Your Ref: OWQC25193
Our Ref: BR/306/19/HH
Please ask for:
Mr F Gardner

6th December 2019

Two storey side and rear extension, single storey rear extension & replacement front porch.

28 Arun Road Bognor Regis

CLIENT	Mrs G Curtis	DRAWING	002 Proposed Plans & Elevations		
SITE	28 Arun Road, Bognor Regis	DATE	31 10 19	AUTHOR	AH
PROJECT	Proposed Extensions & Alterations	SCALE	1: 100 @ A3	STATUS	PRE PL

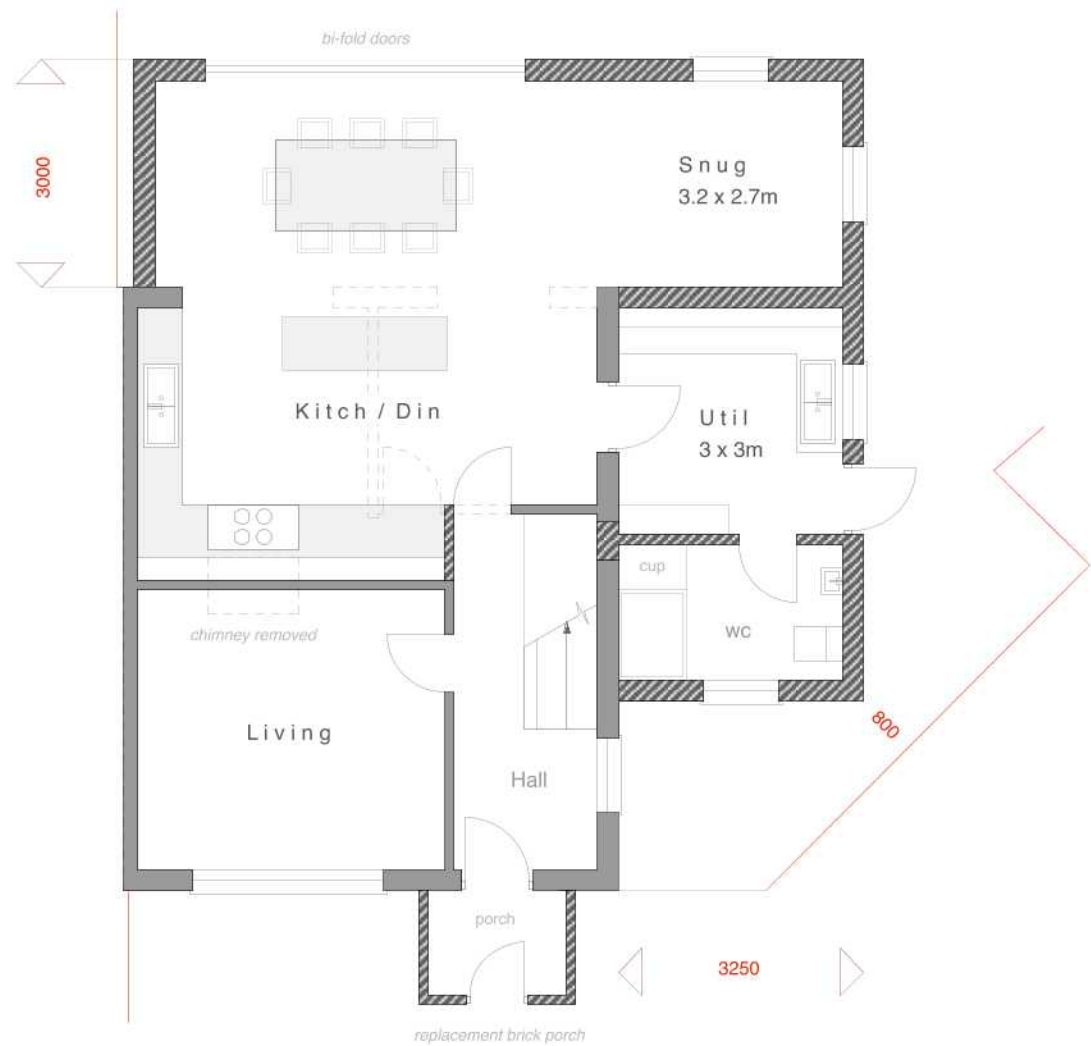
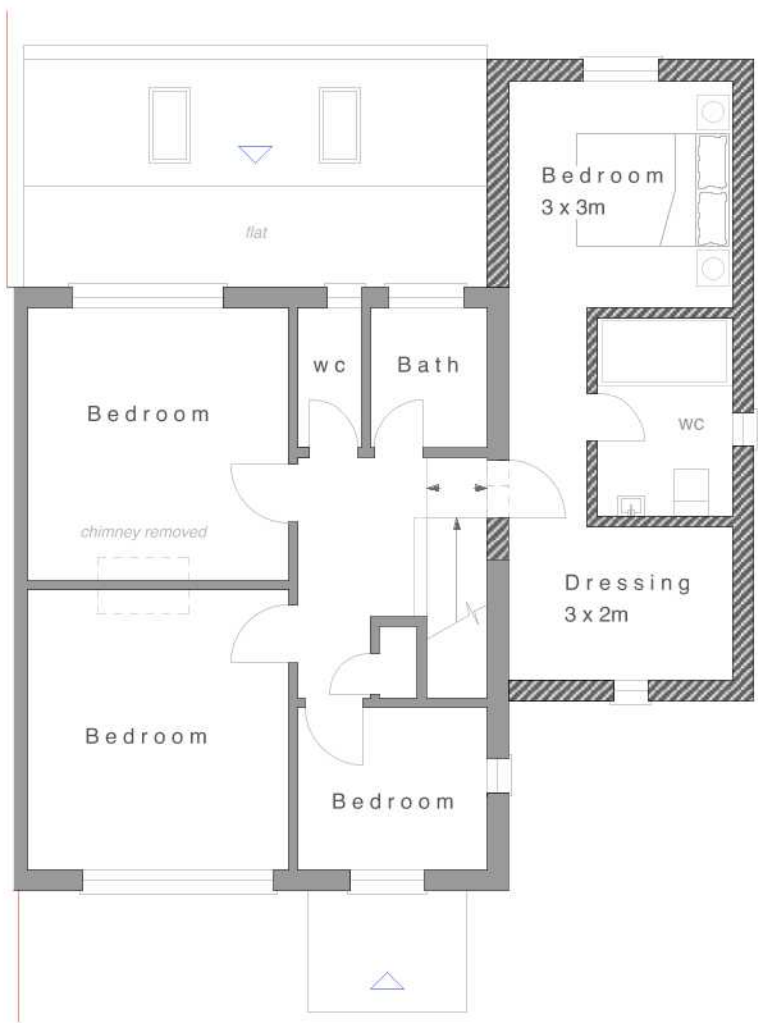
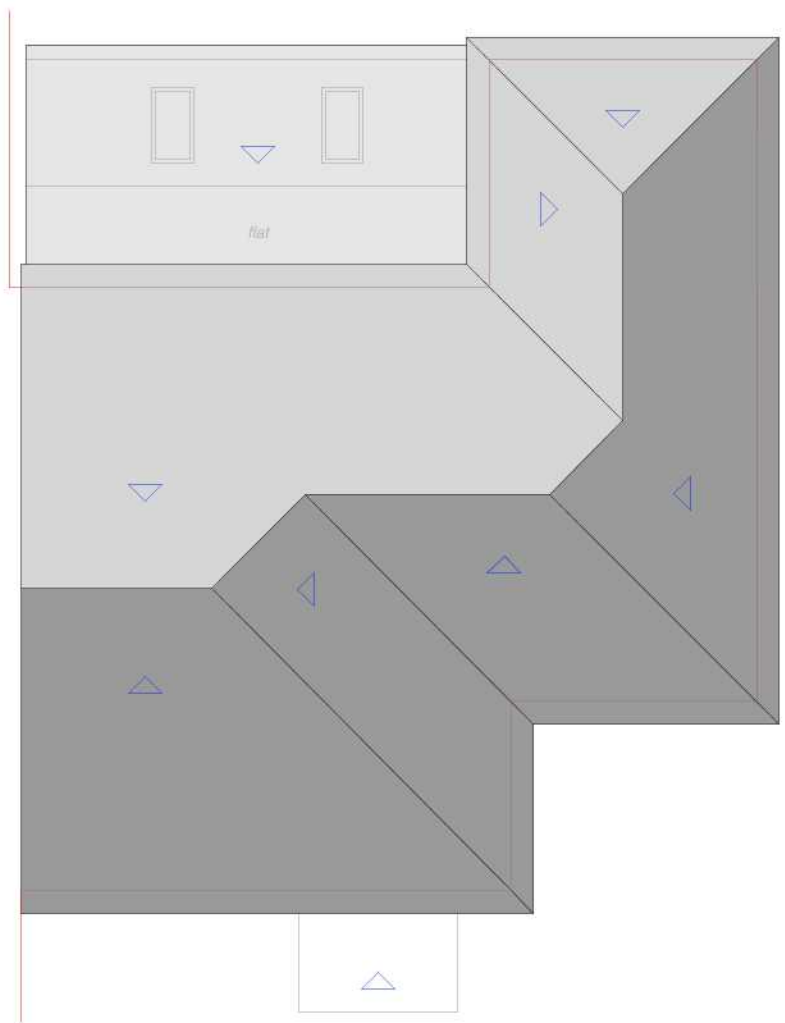
Members consider the proposed two storey side and rear extension to be a departure from the Arun Local Plan Policy D DM4 whereby any extension or alteration should not have an adverse overshadowing, overlooking or overbearing effect on neighbouring properties. The two storey proposals are of an unacceptable size in scale and bulk with the proposed extension being much larger than any other extension in the area. These extensions would unbalance the symmetry of the pair of semi-detached houses and would compromise, and be detrimental to, the existing spatial character and pattern of the street scene contrary to policies D SP1 and D DM1 of the Arun District Local Plan.
